From: Rebecca Halliwell
Sent: 01 June 2017 09:23
To: Sharon Craig
Subject: FW: 3/2017/0287

From: Alan Taylor
Sent: 31 May 2017 16:18
To: Rebecca Halliwell
Subject: 3/2017/0287

PROPOSED SITE PLAN

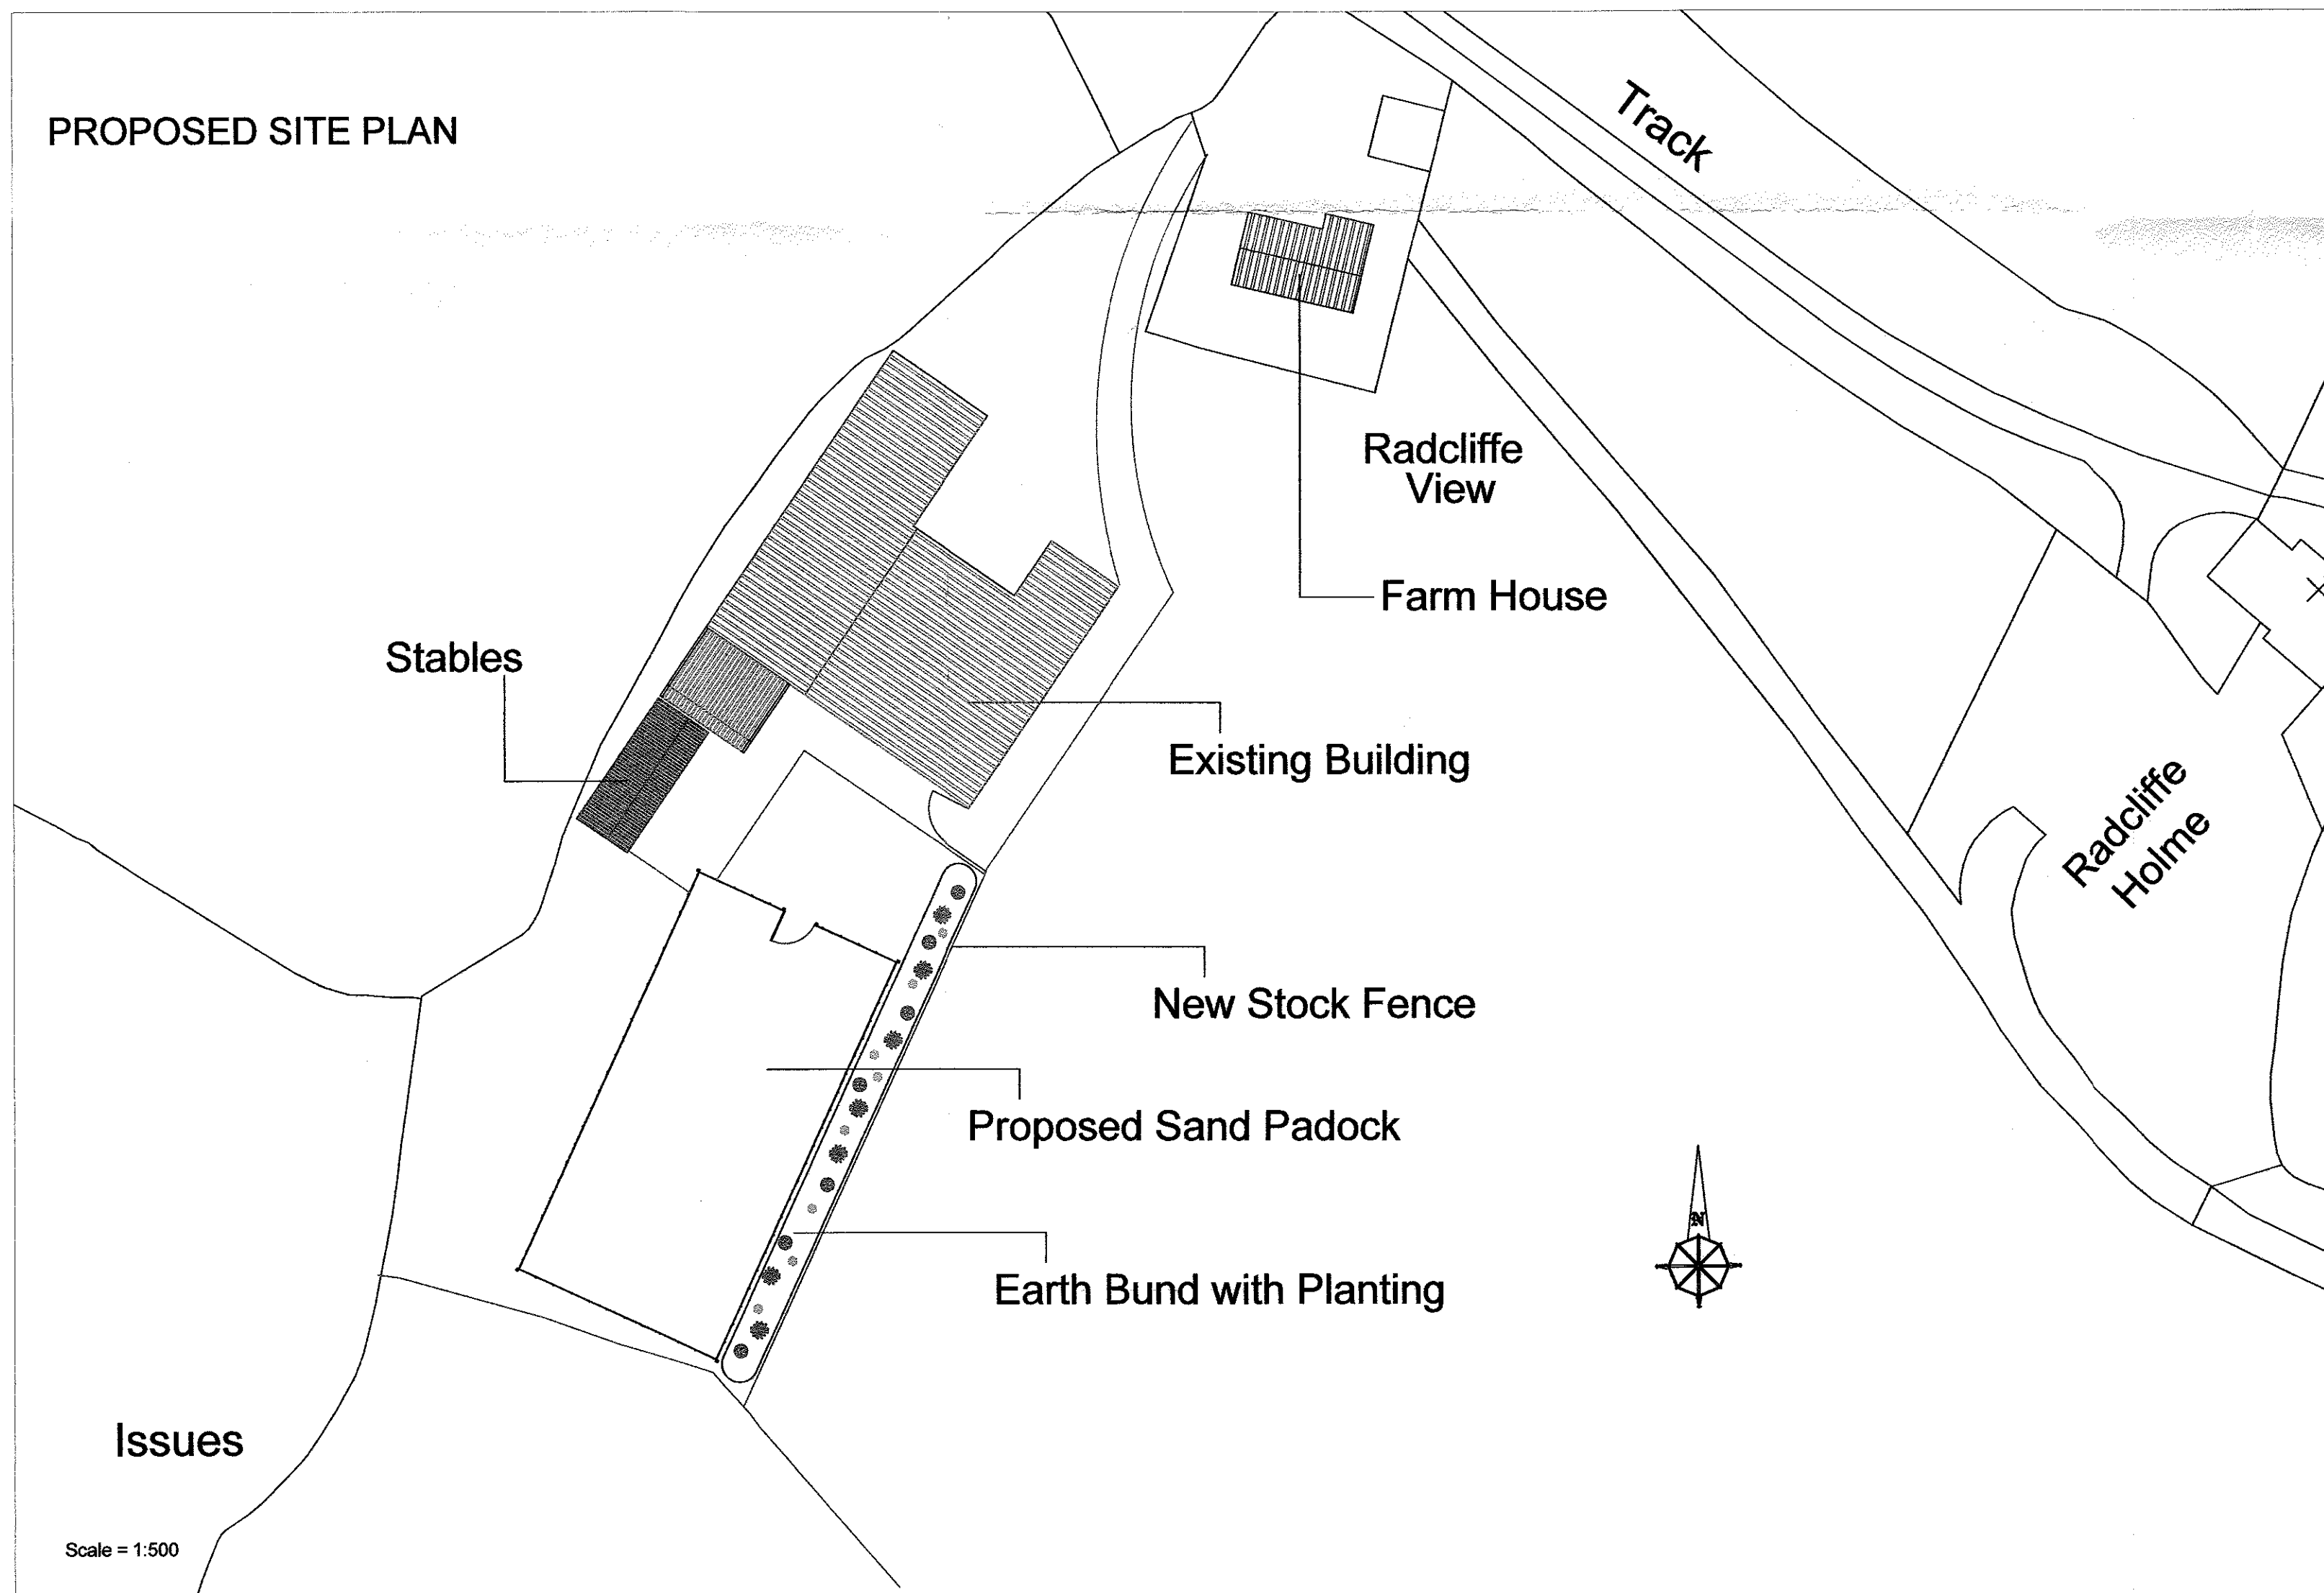
Rebecca. The proposed equestrian paddock looks ok on paper but lighting can be a problem causing nuisance to neighbours. If there is no lighting proposed for the paddock there are no further comments regarding this application.

This should be listed as a condition, at the planning stage. If however the applicant wishes to introduce lighting then we need to consider the application in further details.
